<b>Location of Construction:</b> 157 York St	<b>Owner Name:</b> Barker Wayne	34 Park St	775-1892
	Applicant	<b>Contractor Address:</b> 34 Park Street Portland	2077751892
<b>Lessee/Buyer's Name</b>		Multi Family	<b>Zone:</b>

**Dept:** Zoning      **Status:** Approved with Conditions      **Reviewer:** Marge Schmuckal      **Approval Date:** 07/14/2004

**Dept:** Fire      **Status:** Approved with Conditions      **Reviewer:** Lt. MacDougal      **Approval Date:** 07/19/2004

1 STAIR SECTION
SCALE: 1/2"=1'-0"

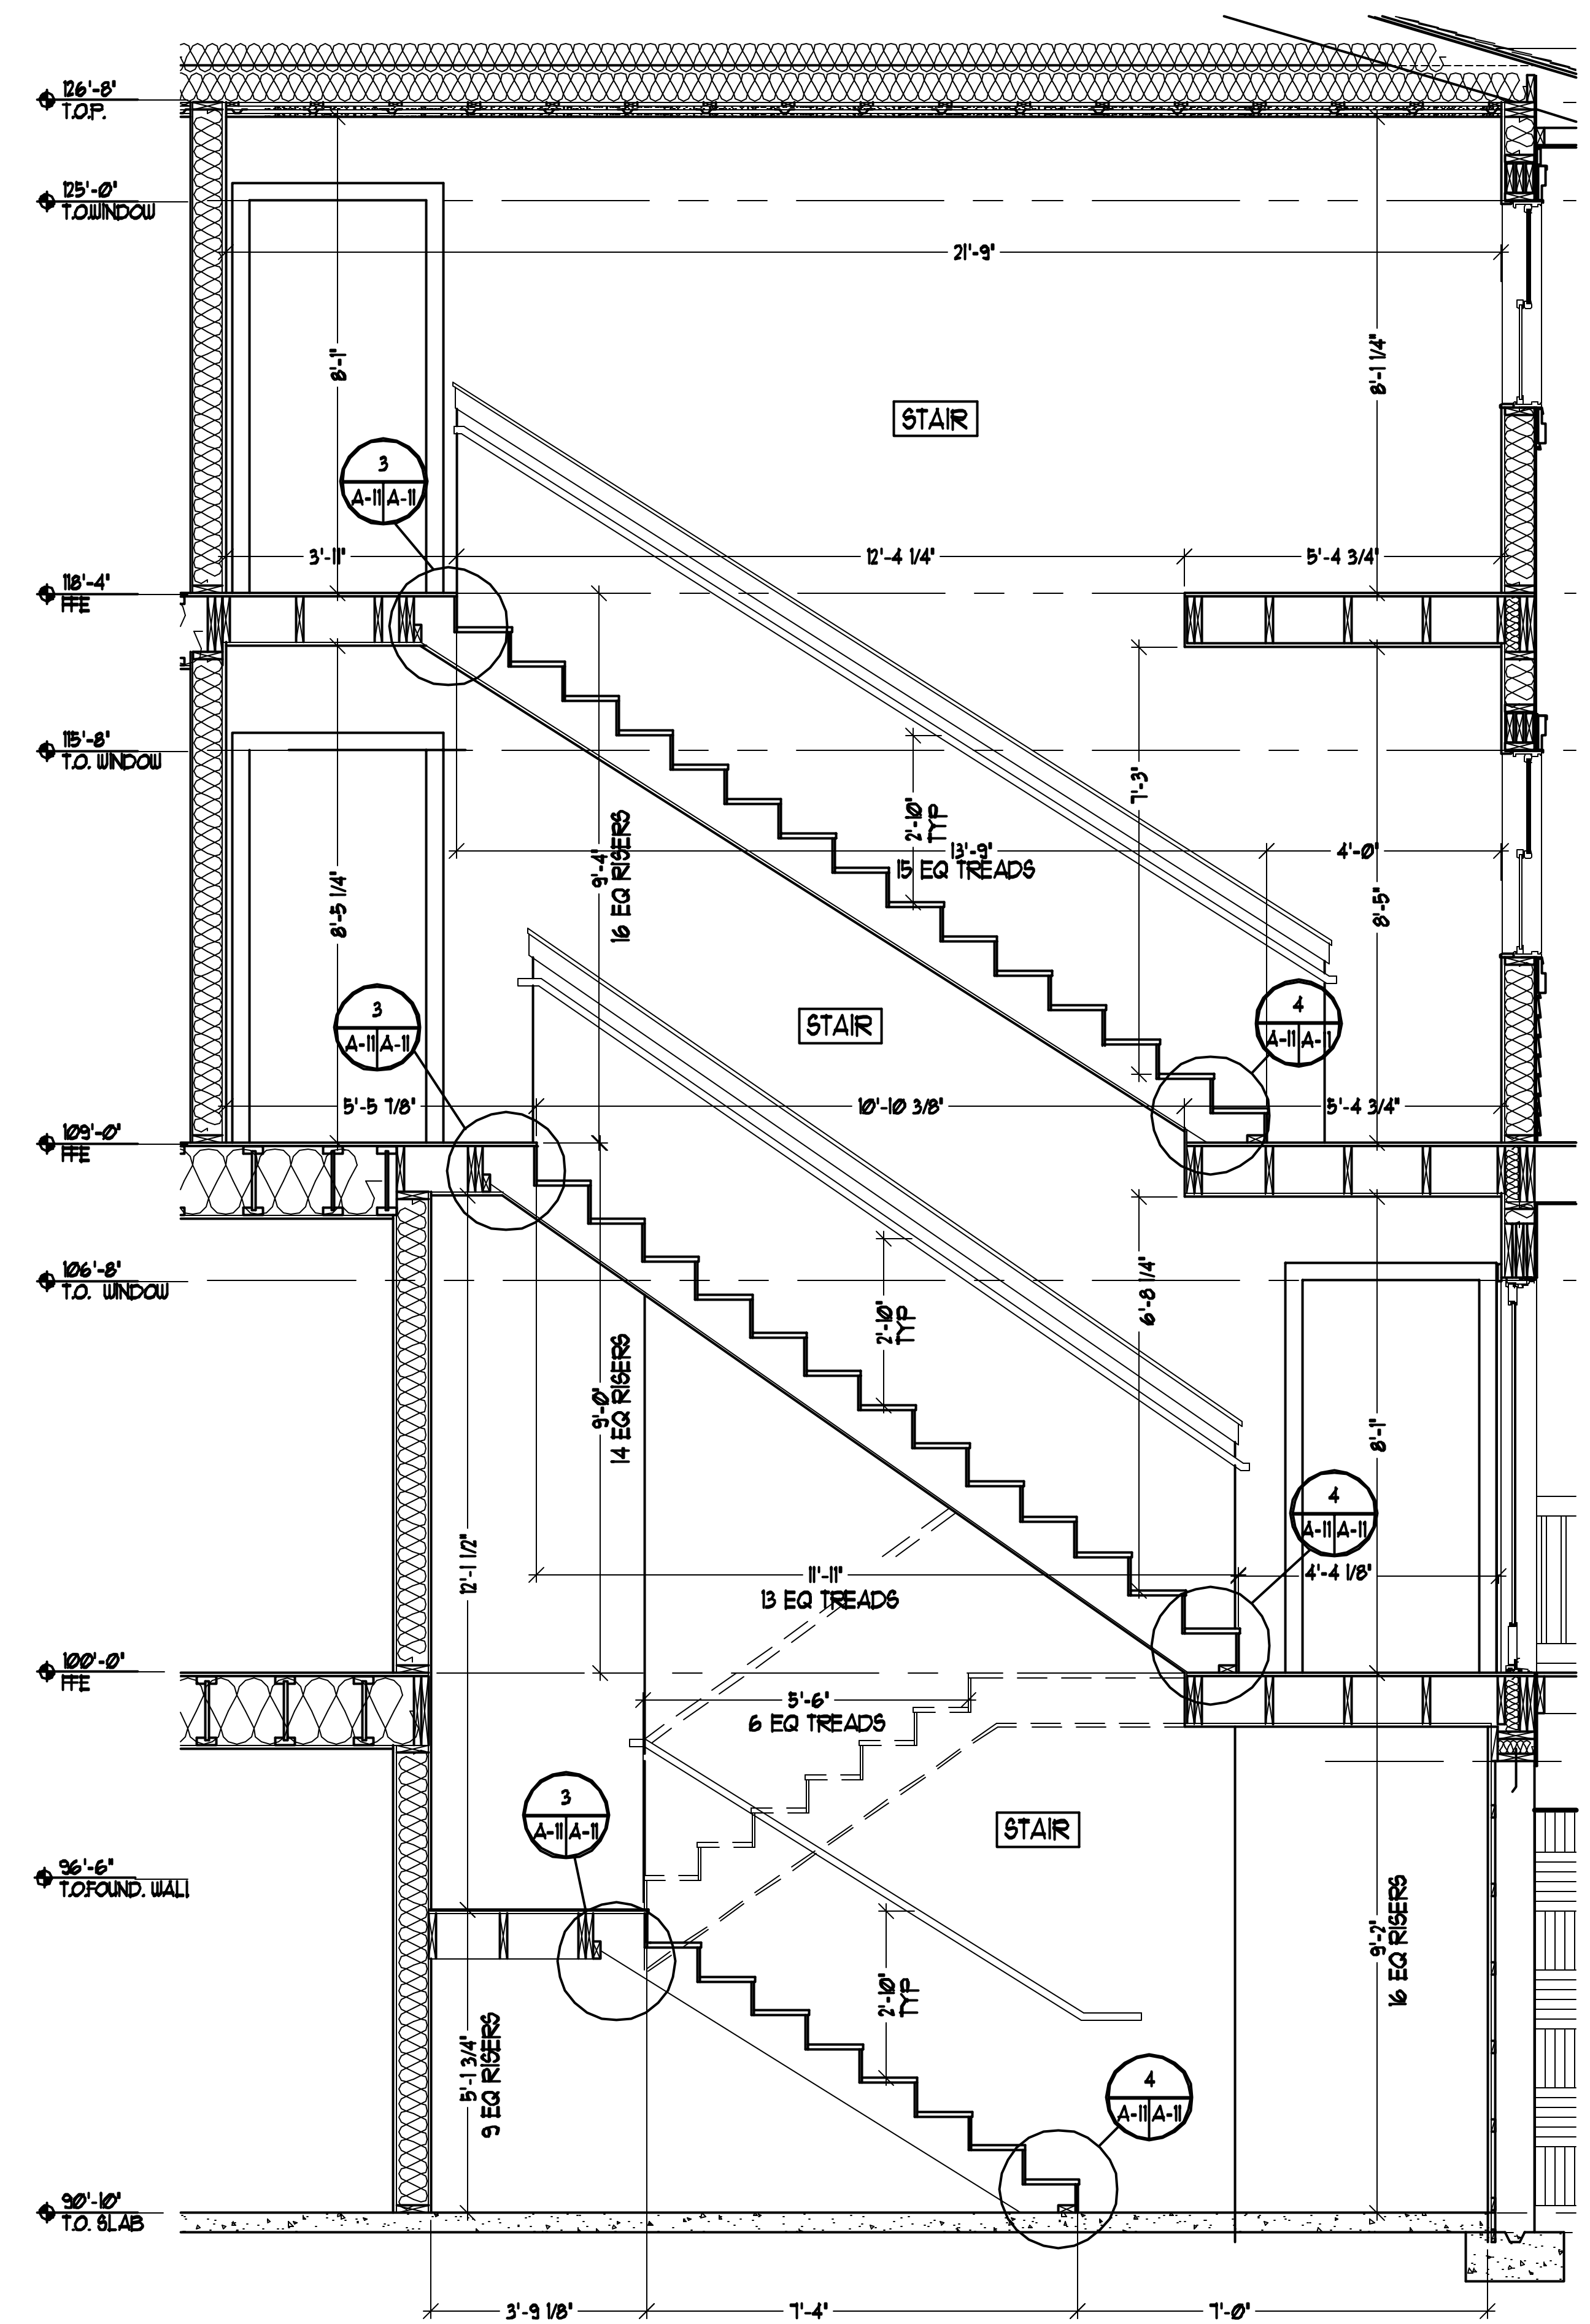
- 1) Guards shall be a minimum of 42" in height
- 2) smoke detectors shall be installed in accordance with NFPA 101, Life Safety Code
- 3) stairs shall have no projecting edge
- 4) stairs shall be 7" maximum riser & 11" minimum tread
- 5) exits shall have a minimum of One hour rating ( doors are now 45 min )
